16 December 2016

**Oakdale South Industrial Estate - s96(2) Modification Application (SSD 6917 MOD 1)  
Submission on behalf of Jacfin Pty Ltd**

As requested we have reviewed the following noise report prepared by SLR consulting with respect to the application by Goodman to modify the Oakdale South Concept and Stage 1 Approval:

1:2500 @ A1  
1:5000 @ A3  
15 Feb 2017  
OAK MP 03 (P)

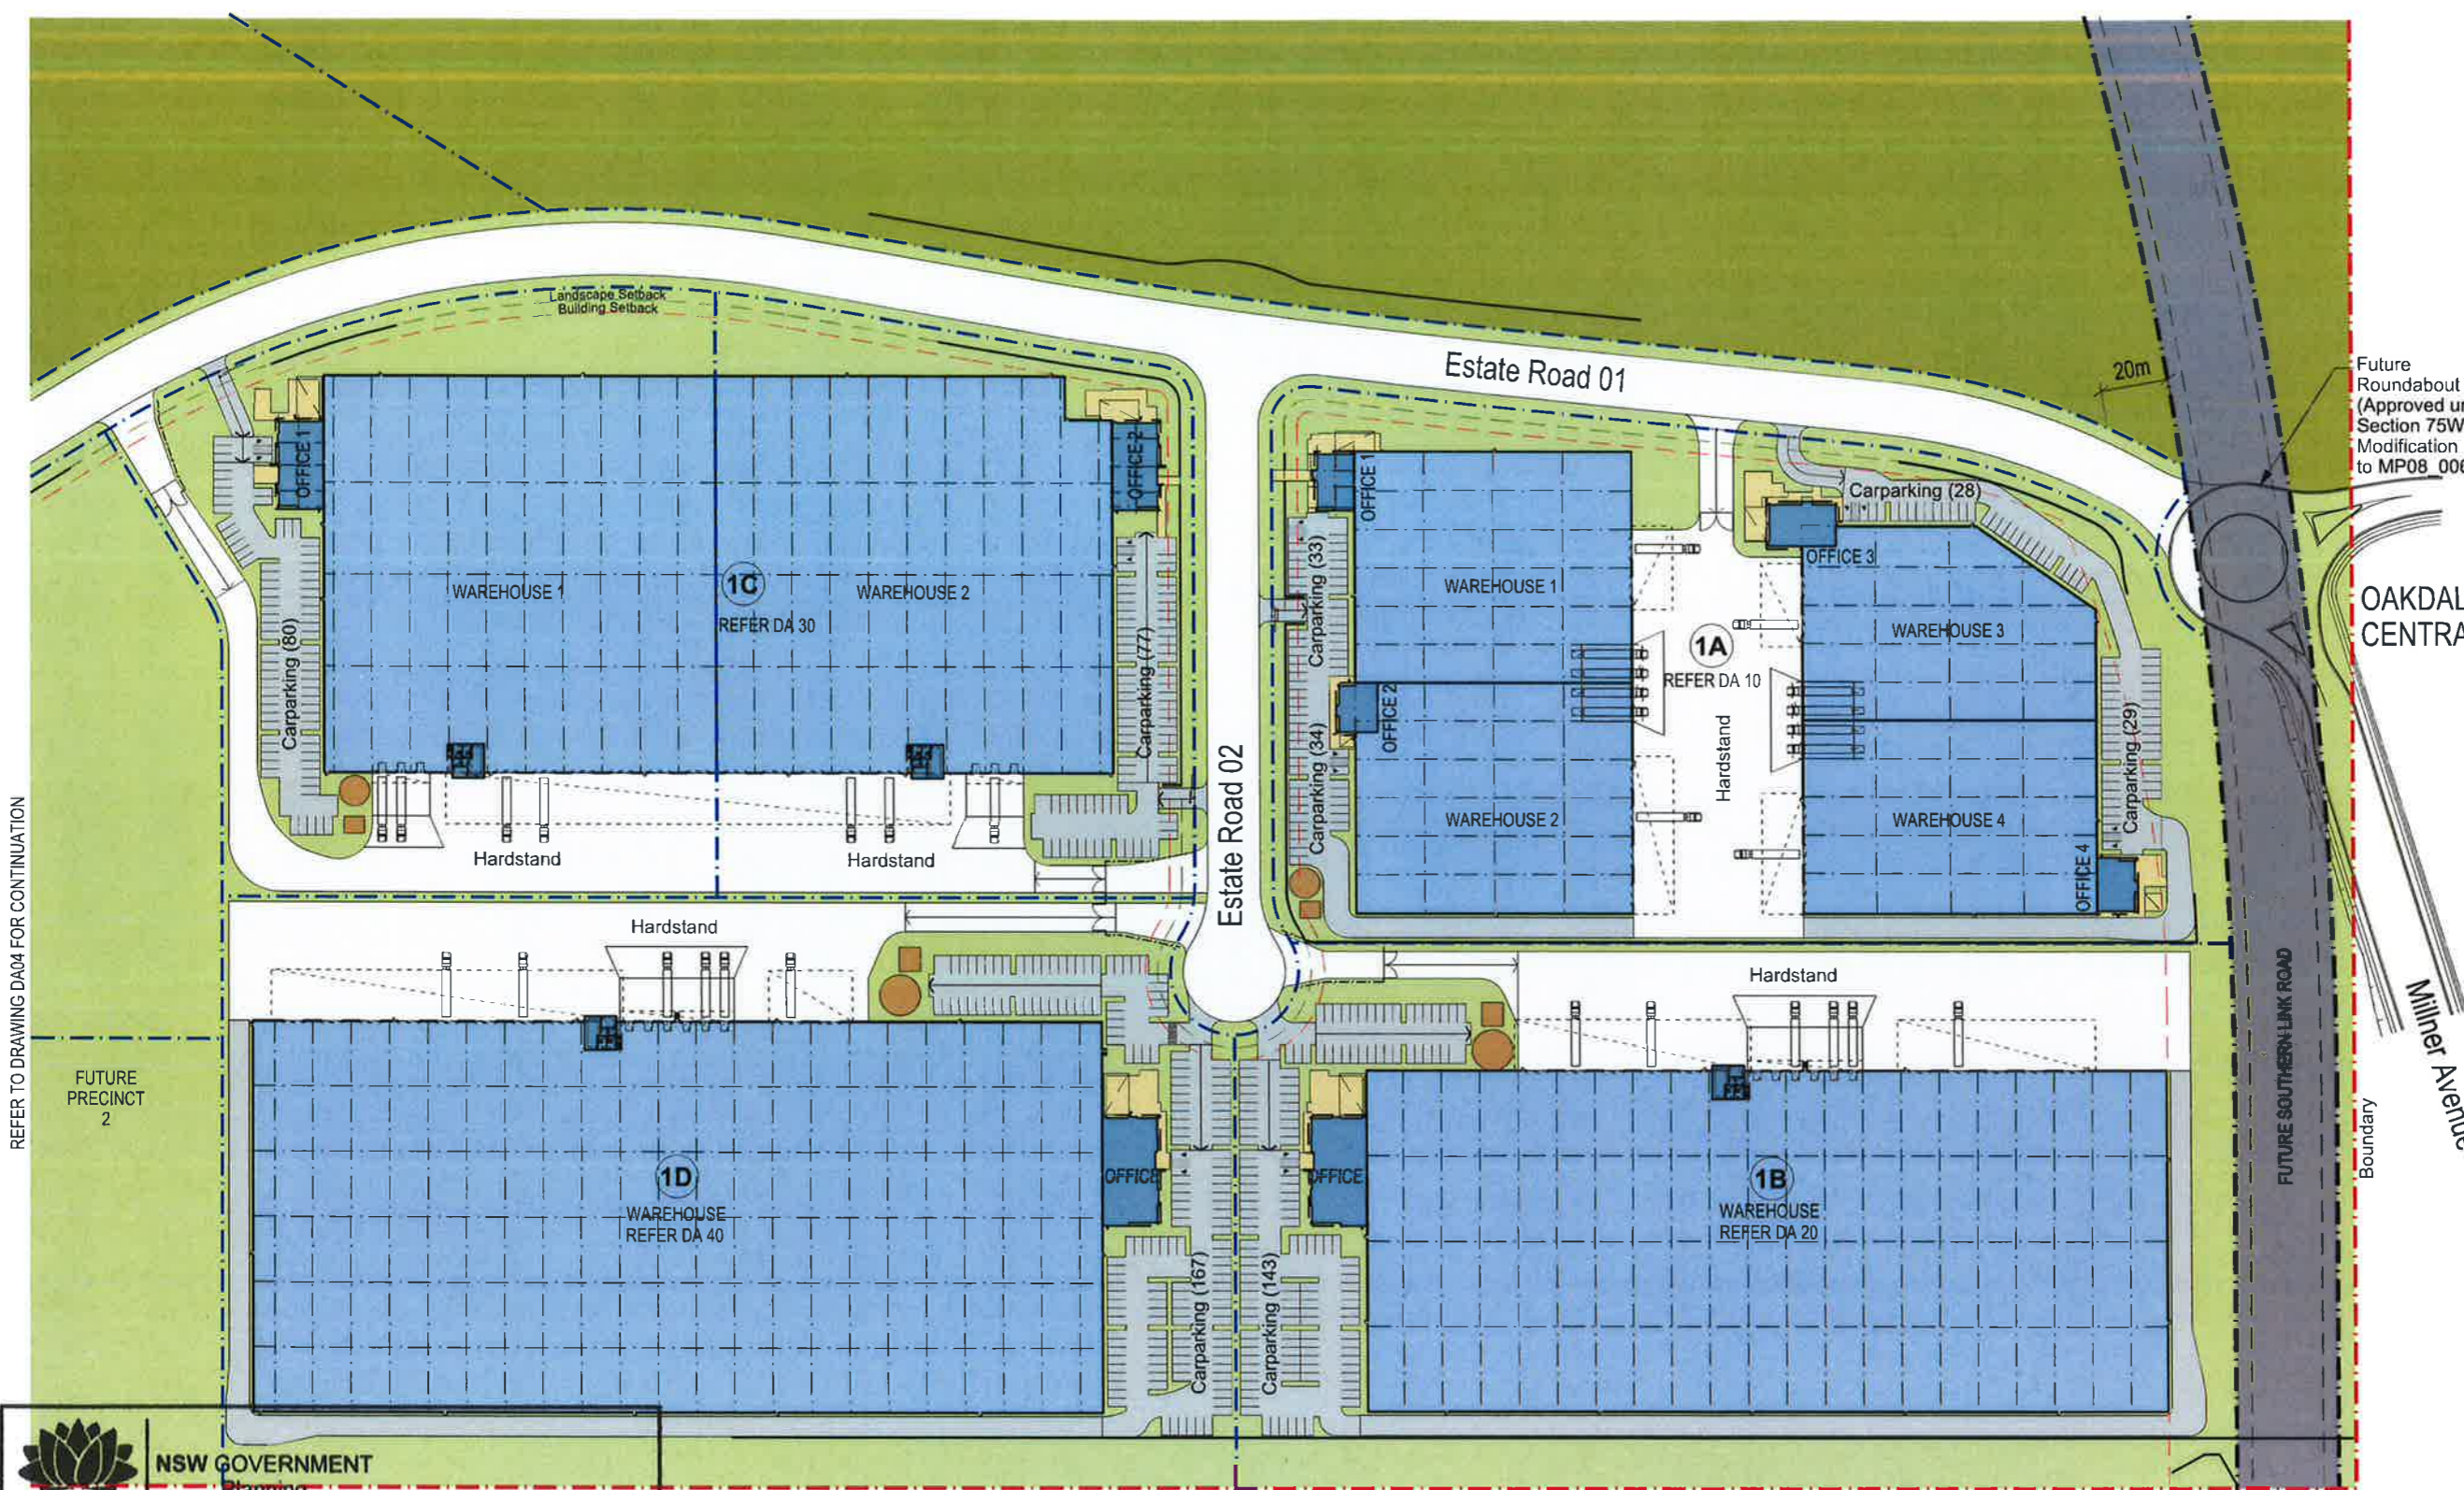
The revised masterplan on page 12 of the EIS for the Modification Application shows Estate Road 03 terminating at a cul-de-sac a number of metres short of the Lot A boundary. There does not appear to be any proposal to continue the road or the road reserve to the boundary of Lot A. If approved, this would have the result that a small area of privately owned land will remain between Estate Road 03 and Lot A, preventing any future connection without the acquisition of land.

Jacfin submits that this is unacceptable and that the conditions of consent for the Modification Application should require the road reserve of Estate Road 03 to be continued and dedicated to the boundary of Lot A.

The Modification Application also proposes a minor realignment of Estate Road 03. The centre line of the realigned Estate Road 03 is approximately 847.5 metres from the northern boundary of the OSE site and does not align with the centre line of Local Road 1 on Lot A, which is approximately 830 metres from the northern boundary of Lot A. The location of Local Road 1 was approved under Concept Plan Approval MP 10\_0129. It is essential that the location of Estate Road 03 align with the approved location of Local Road 1 to preserve the opportunity for a future connection between the OSE and Lot A. Jacfin submits that the Department should require Goodman to provide revised plans with the centre line of Estate Road 03 relocated 17.5 metres further north, so that it aligns with Local Road 1.

- (f) the conditions of consent for the Modification Application should require the continuation and dedication of the road reserve for Local Road 03 to the boundary of Lot A and the Department should require Goodman to provide updated plans with the centre line of Estate Road 03 relocated 17.5 metres to the north to align with the approved location of Local Road 1 on Lot A; and
